Hi Stacey,

Environmental Health Officer (Pollution Control) – Regulatory Services
Public Health Directorate
Barnsley Metropolitan Borough Council
PO Box 634
Barnsley
S70 9GG

Appendix 13.1 – Figure 6
Road Traffic Noise Level Changes – DMOY to DSOY (Short Term Changes
in dB $L_{A10,18hr}$ With Proposed Development and Link Road)

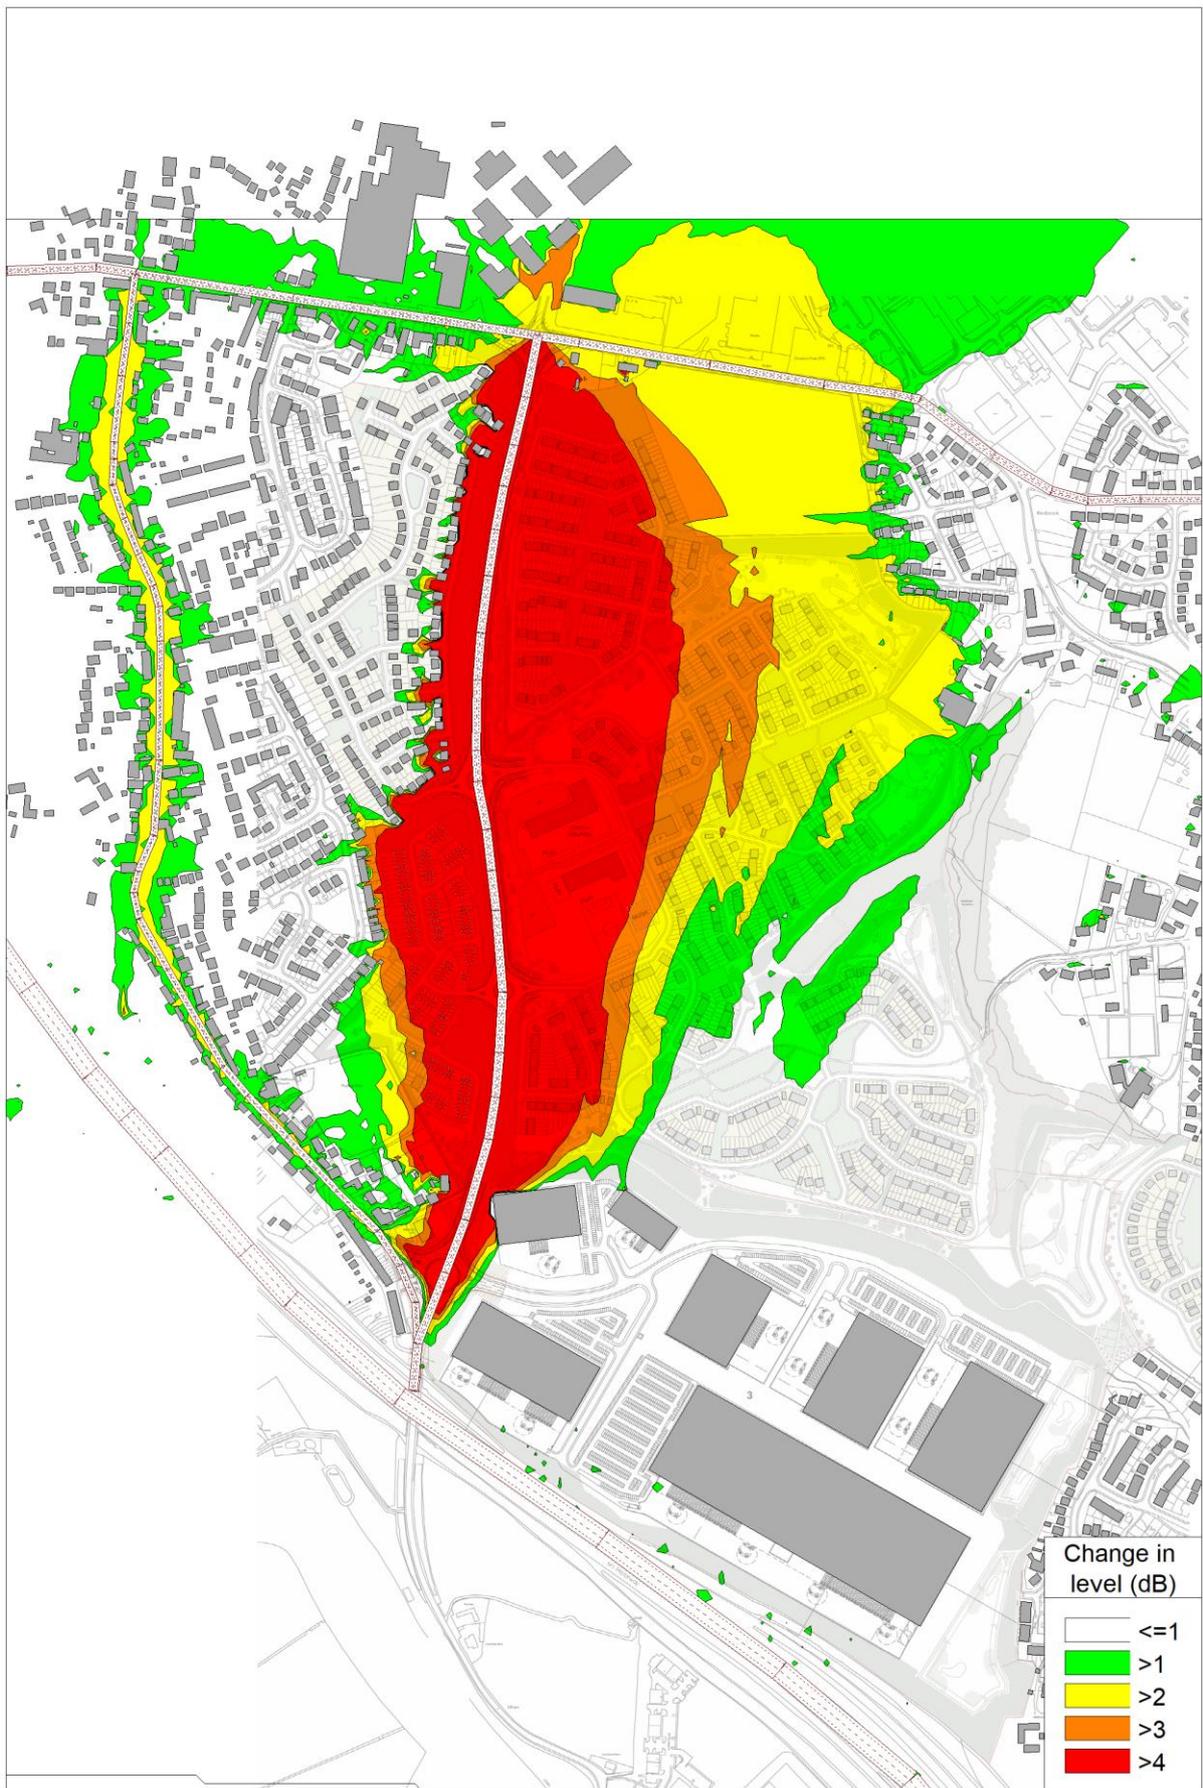
The current noise assessment refers to the 2026 scenario being:

- Phase 1a – i.e. Phase 1 of the residential development (up to a worse-case of 275 no. dwellings for assessment purposes) including the primary school and the first part of the Link road running from Barugh Green Road to the northernmost internal round.

I would also request that a further noise assessment is carried out which includes the full link road and the effects of this on current and proposed residents.
